## PLANNING CONSULTATION RESPONSE

<b>Application No</b>	2025/0915
<b>Proposal</b>	Installation of 2no. liquid oxygen storage vessels with vaporisers for medical gas use with associated security and screen fencing and artwork.
<b>Address</b>	Barnsley District General Hospital, Gawber Road, Old Town, Barnsley, S75 2EP
<b>Date of Consultation Reply</b>	10/02/26
<b>Consultee</b>	Nik King, Senior Urban Design Officer

These are the second set of design comments on planning application 2025/0915. These are in the light of amendments and additional information provided by the applicant, received on 3<sup>rd</sup> February.

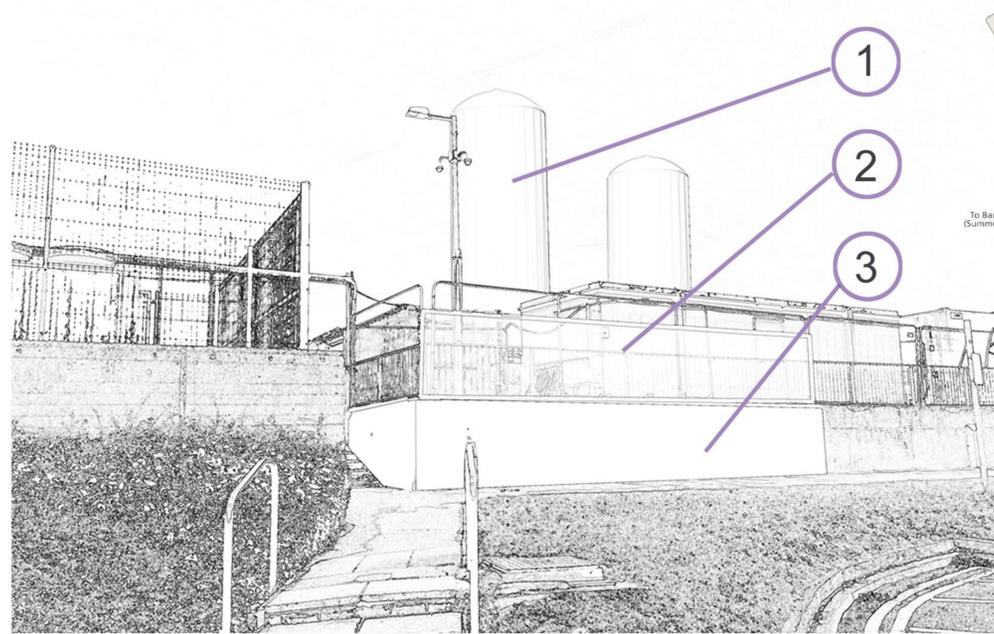
I note the progression of each of the three artwork designs- a tree design on the cylinders will hopefully be easier to reproduce through painting than a detailed flower head design, the corten steel design has a high degree of transparency and the bolder design of the animal shapes on the (cleaned) concrete retaining wall will help to make the pedestrian environment a bit more friendly and joyful.

- Detailed designs for the three artworks and their setting

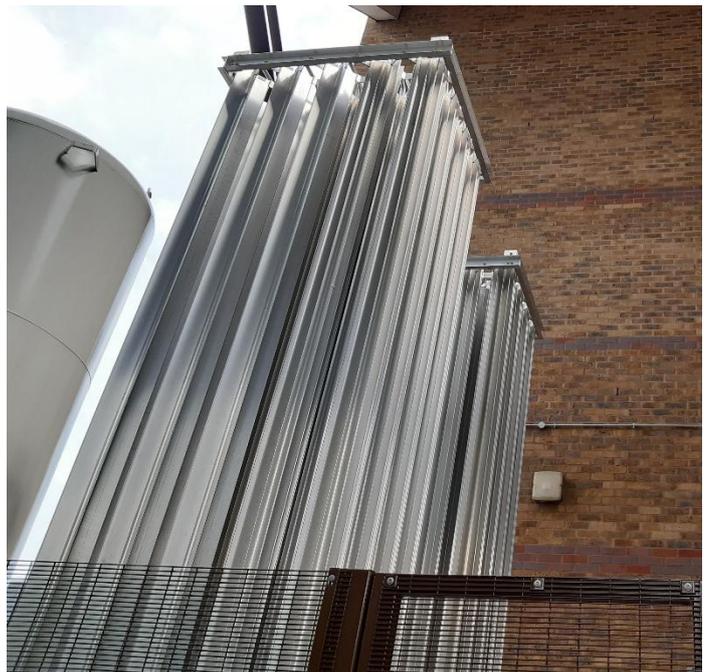
I note the annotation on the proposed site plan regarding proposed changes to the lighting in the vicinity.

Given the tight funding timescales, I am fine with your suggestion that the final designs of the three artworks and their setting are confirmed by condition. I would suggest that finalised detail of the changes of the lighting is annotated on the proposed site plan, (rather than be dealt by a separate condition).
